Application No: P/153/21/RES

Site Address: Land South of Summer Lane and West of Pagham Road Pagham

Planning Reference: P/153/21/RES

At this stage we would raise a holding objection and request further information as detailed below.

Drawing Title **Proposed FW & SW Drainage Strategy
(Southern) Sheet 1 of 2**

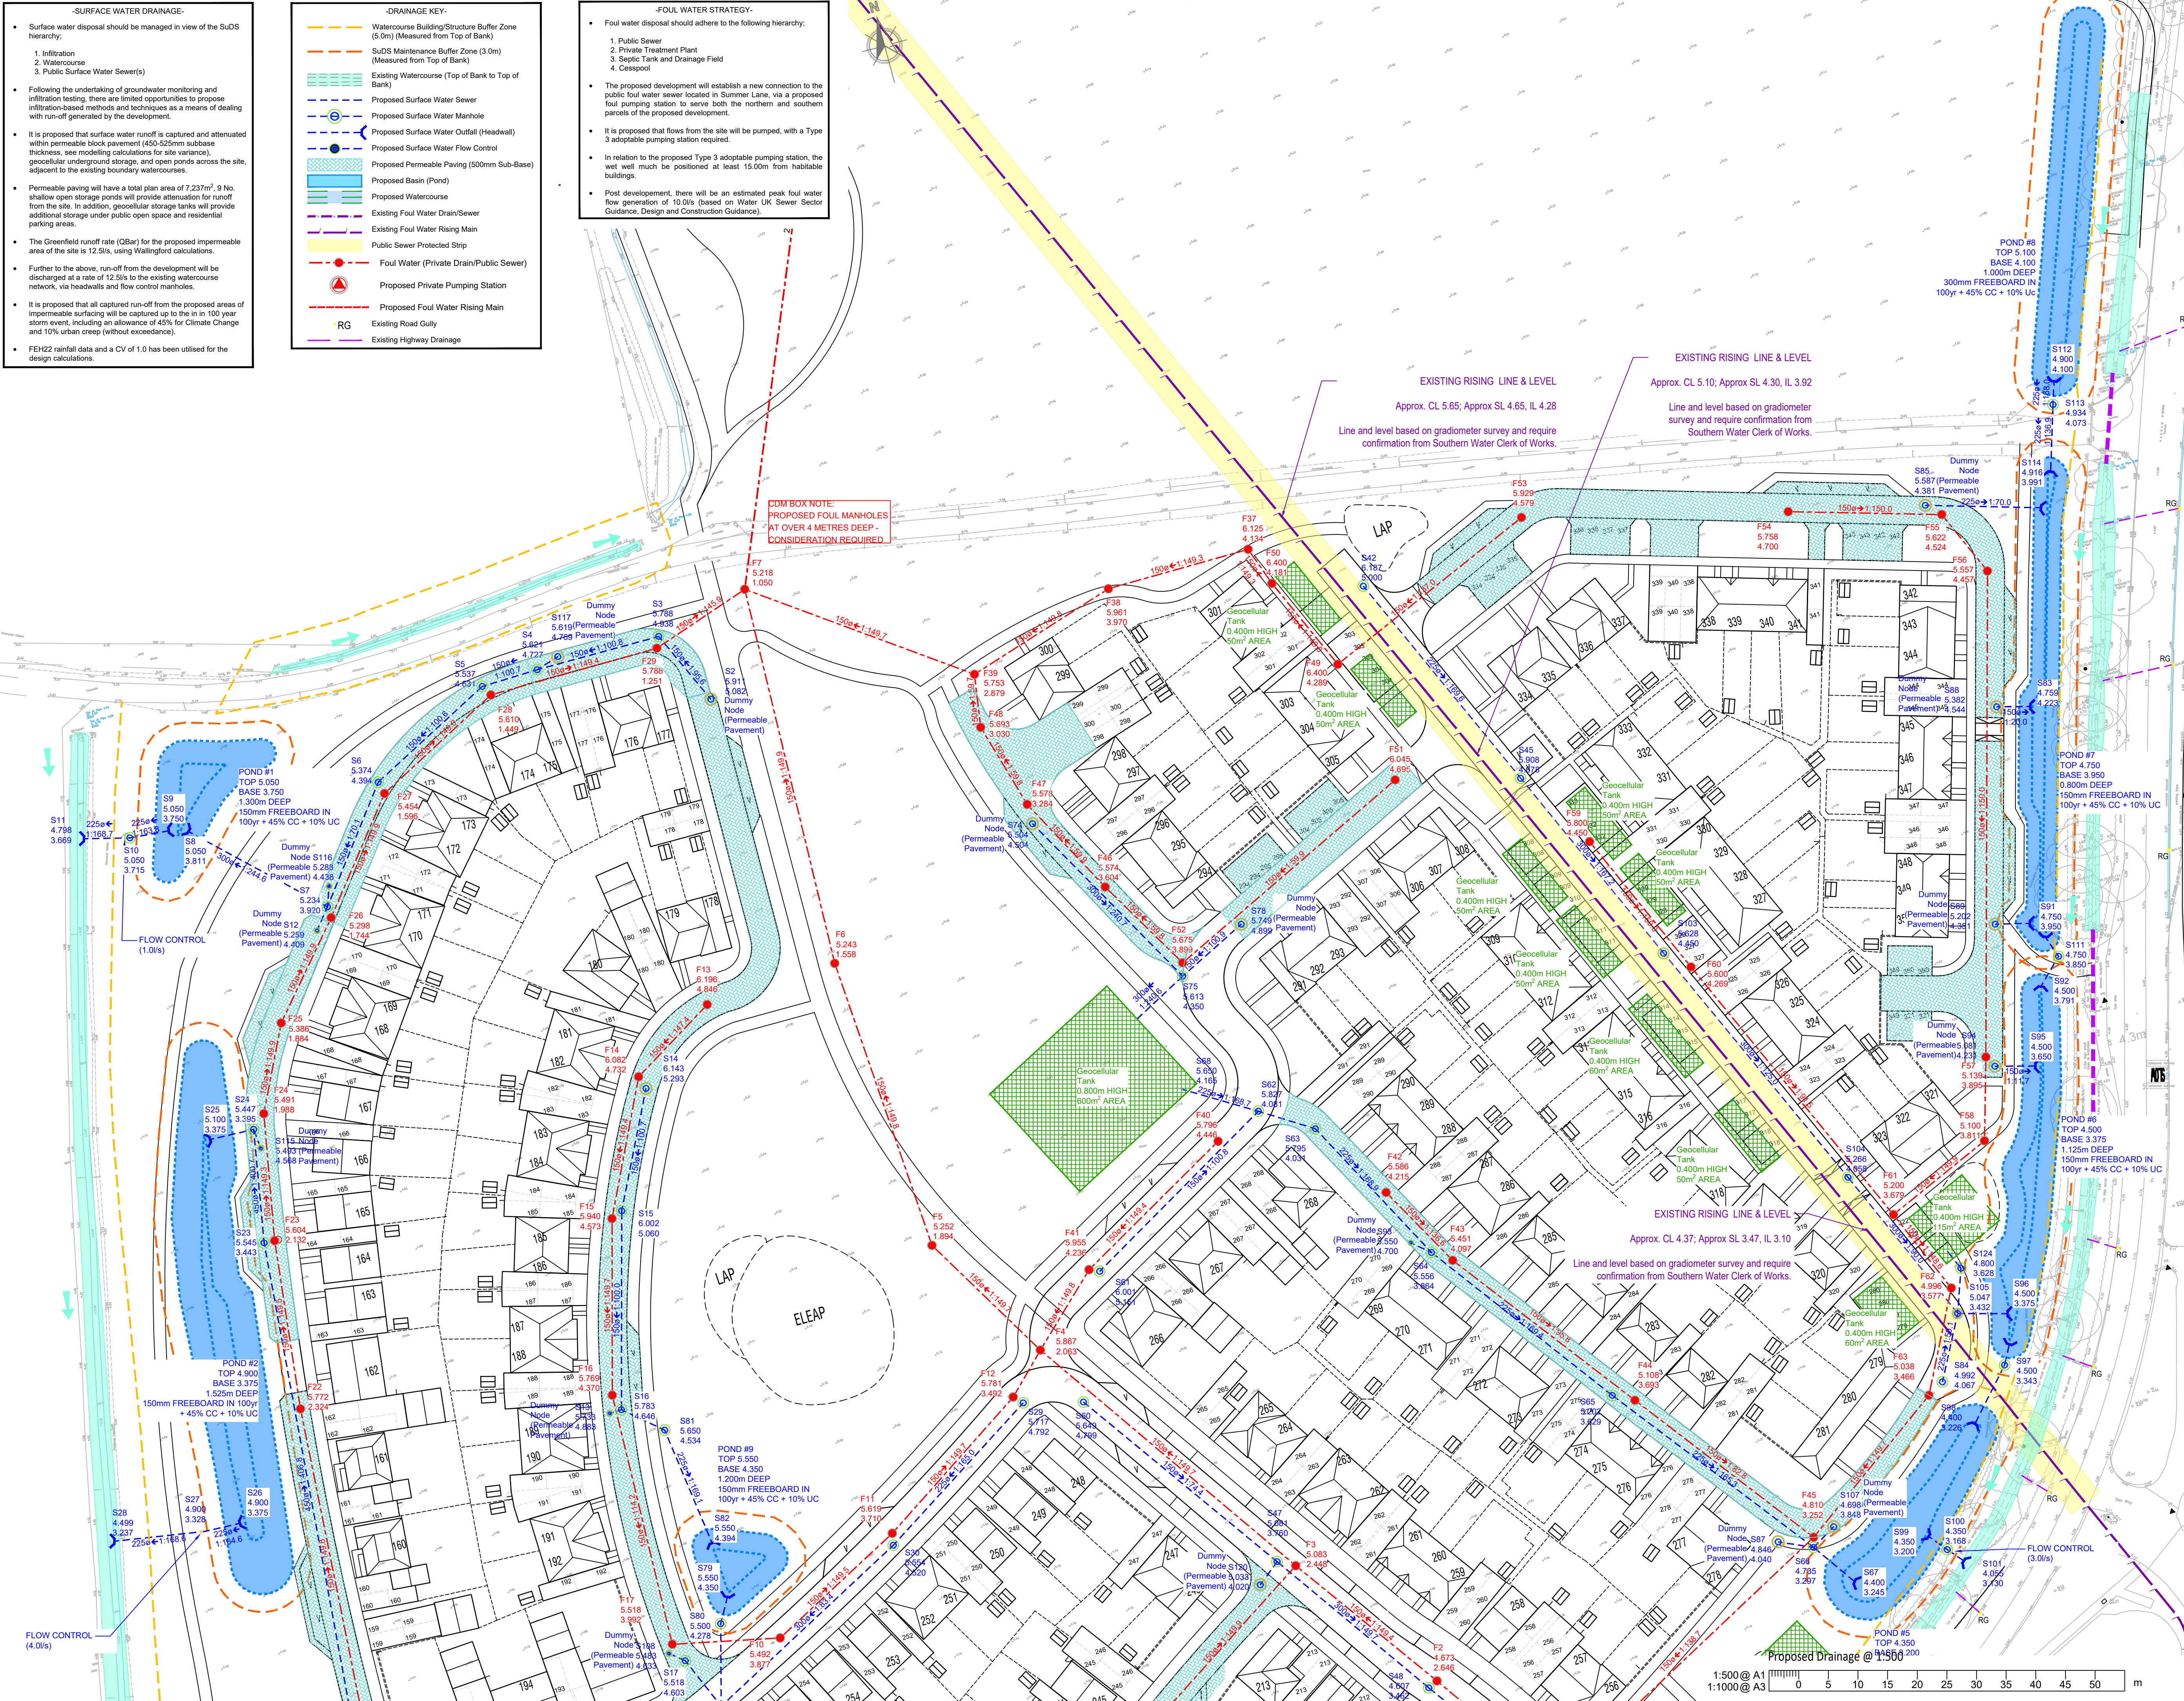
Root Protection Areas and proposed / existing trees should be included on the proposed drainage drawings to ascertain the viability of the strategy and the impact on the existing and proposed trees. Some of the proposed and existing trees appear close to the proposed attenuation structure and drainage features.

We note the change to the discharge rate for the development. Please supply Greenfield run-off rate calculations to support the updated discharge rates.

Please provide confirmation that FEH 2013 data has been used for the calculations. If the FEH data has not been used, please supply calculations using the FEH 2013.

A minimum of two perpendicular cross-section must be provided for all SuDS structures proposed within the drainage strategy this is to ensure that the proposed size and extent of the basins with the associated earthworks will fit within the area proposed for these basins.

Some of the proposed attenuation basins appear to be still encroaching on the watercourse buffer (example Pond 11). The proposed basins will need to be fully outside the watercourse buffer zone.
